Review of the Noise Impact Assessment for MOD 3 of the Sydney Super Yacht Marina proposal MP09_0165.

I wish to comment on the Noise Impact Assessment (NIA) report for MOD 3 of the Sydney Super Yacht Marina proposal MP_0165.

Figure 2 Comparison of current approval and proposed modification

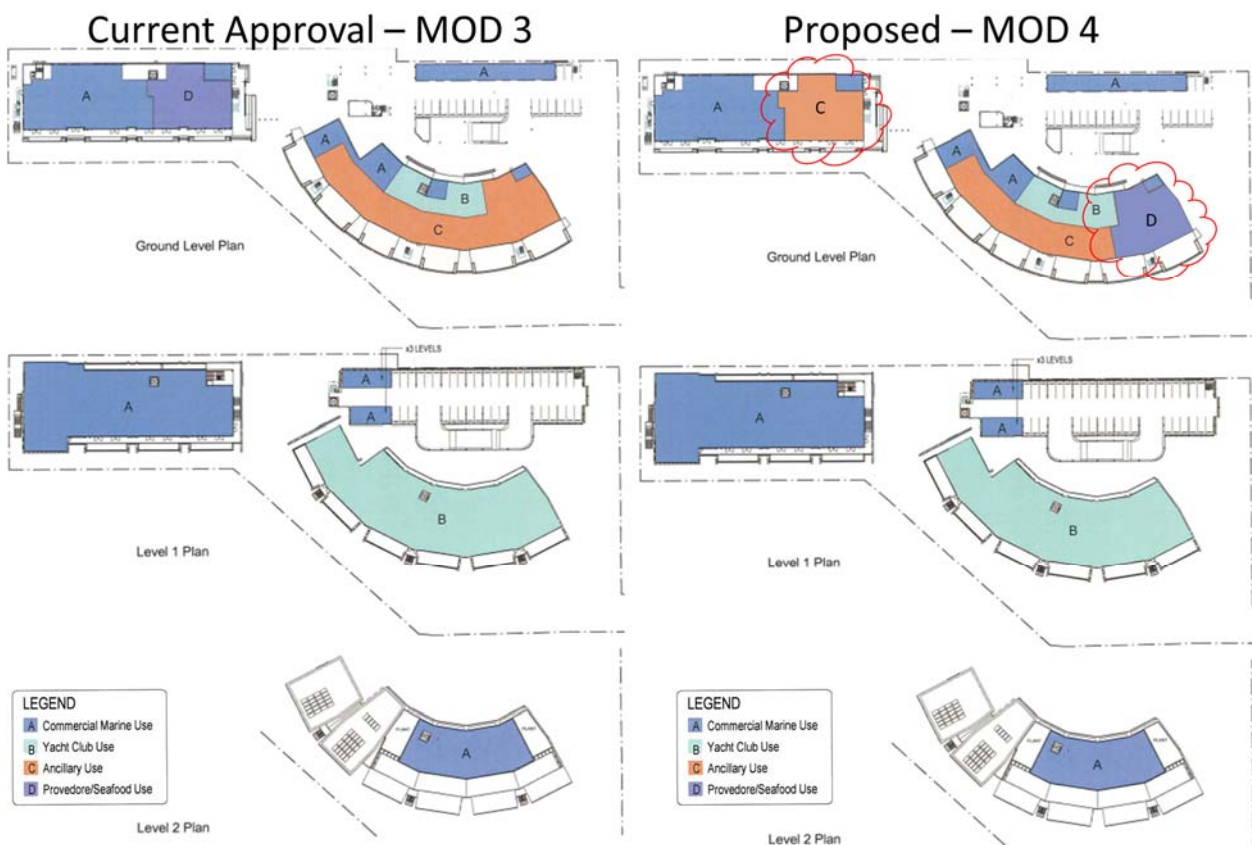
The relocation of uses between the western and eastern buildings has put more of the noise producing uses into the eastern building, which is closer to R5.
